Application No: P/86/20/PL
Site Address: Bowley Farm Bowley Lane South Mundham Chichester PO21 1NB
Description of works: Retention of 4 No. mobile homes for countryside workers together with drainage & service connection provision in connection with permission P/72/09 as varied by P/22/17/PL. This application is in CIL Zone 5 (Zero Rated) as 'other development'.

Thank you for your internet representation made on 1st October 2020 which has been recorded as an objection with the comments as follows:

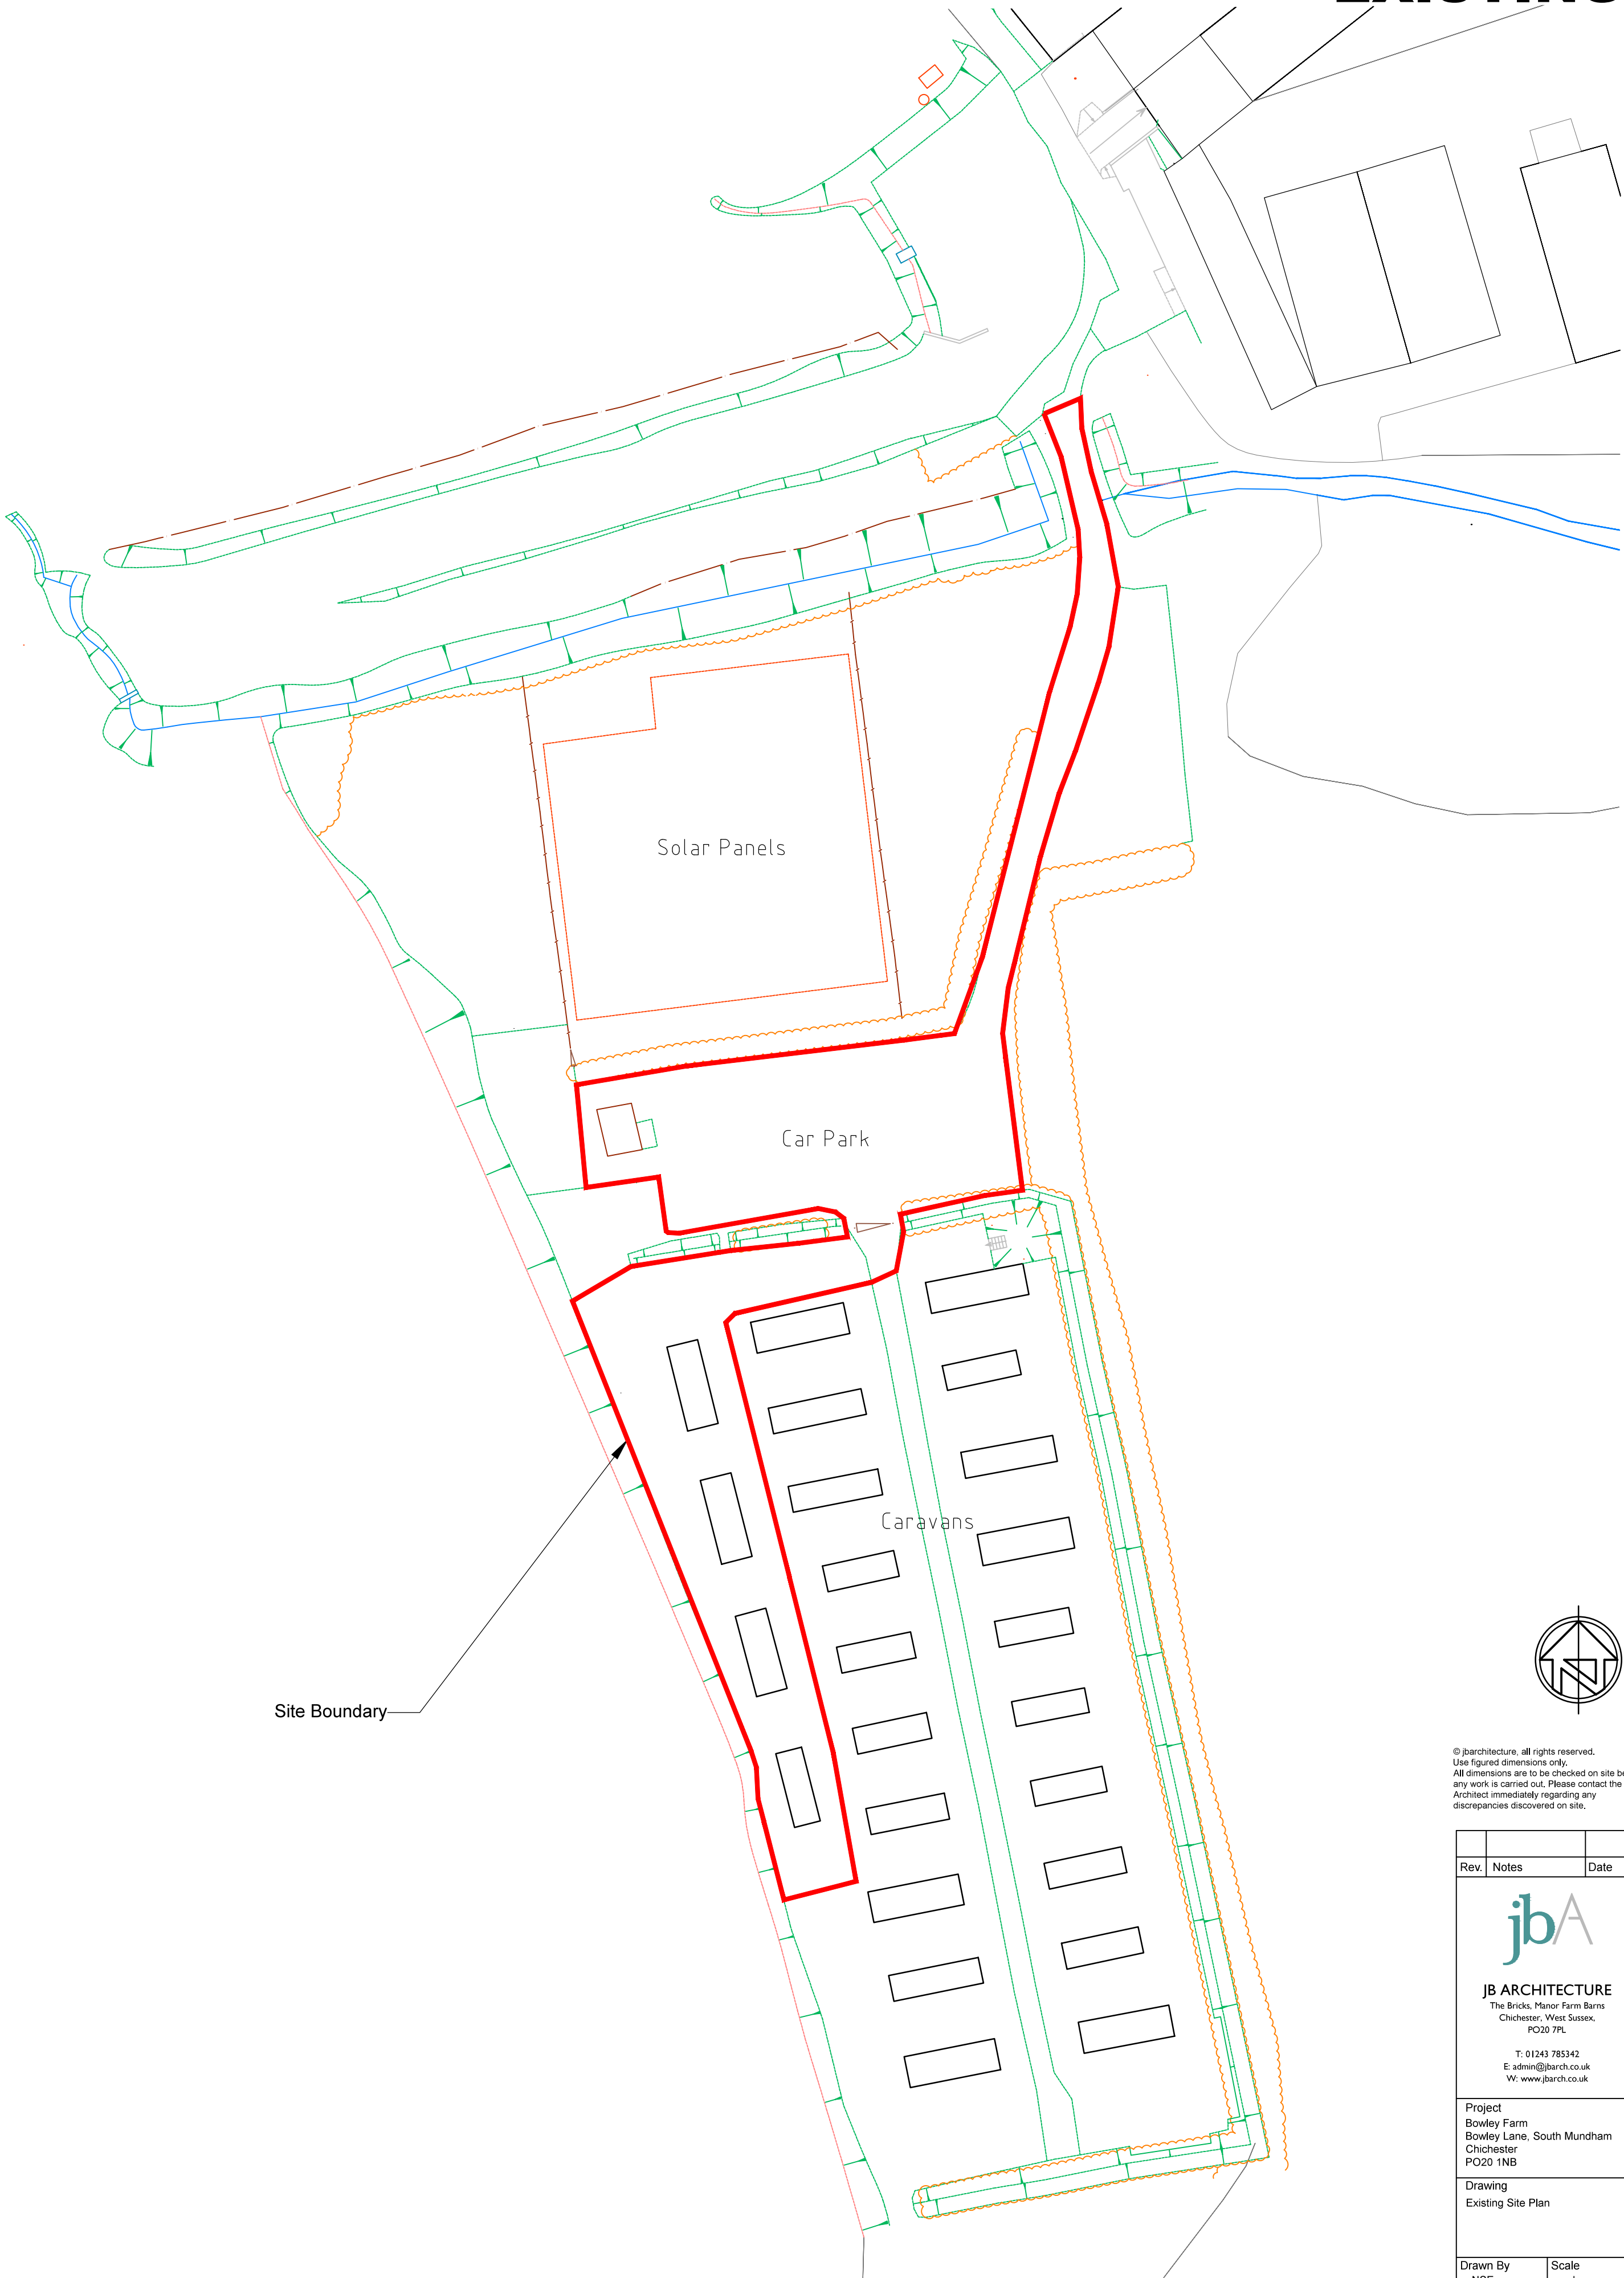
I want to specifically query two things. Firstly, the number of caravans on the Farm. I am pretty sure there are more than shown on the site plan. And secondly, I question whether it is just seasonal workers in residence, rather some folks seem to have lived there for some time.
